DATE: October 2, 2019

TO: Kari Parsons, PCD-Project Manager

FROM: Kyle R. Campbell, P.E. – Division Manager

SUBJECT: Response to “**PUDSP-19-004 – Midtown Collection at Hannah Ridge Second Submittal**”, dated September 9, 2019

MIDTOWN COLLECTION AT HANNAH RIDGE
 FILING NO. 1
 DEVELOPED CONDITIONS DRAINAGE MAP

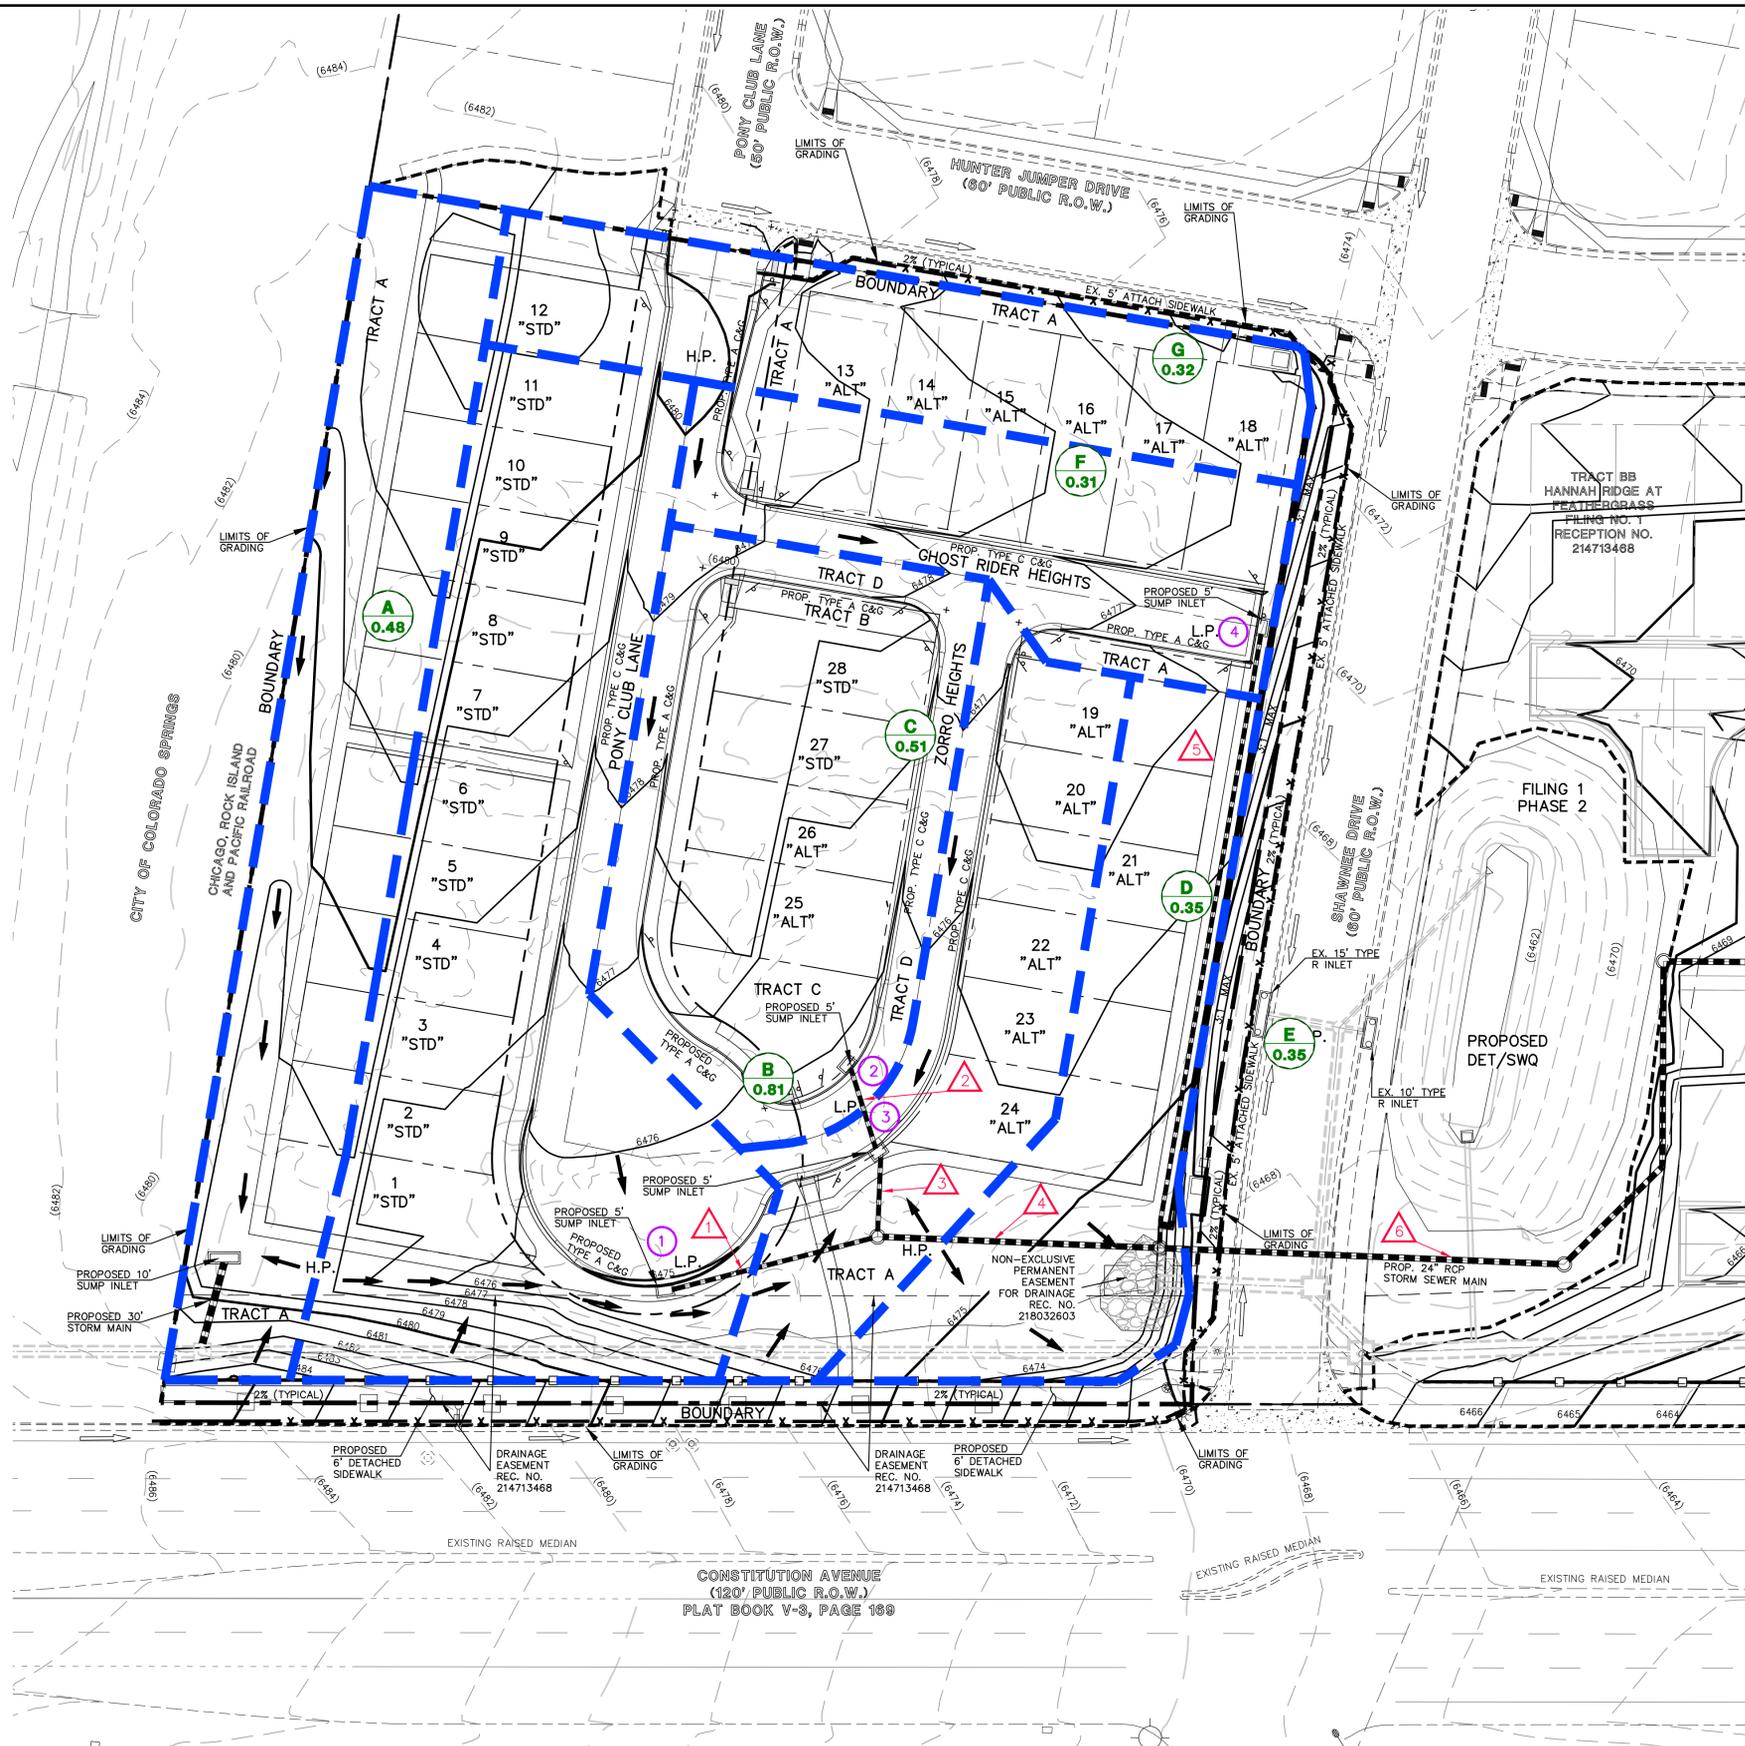
2. The untreated areas need to be less than 1 acre in size and less than 20% of the developed area. **Unresolved; Basin outfalls were minimally modified from the first to the second submittal. Please provide a table on the drainage plan that verifies the 1 acre/20% requirement is met.**

**RESPONSE: Table added as requested.**
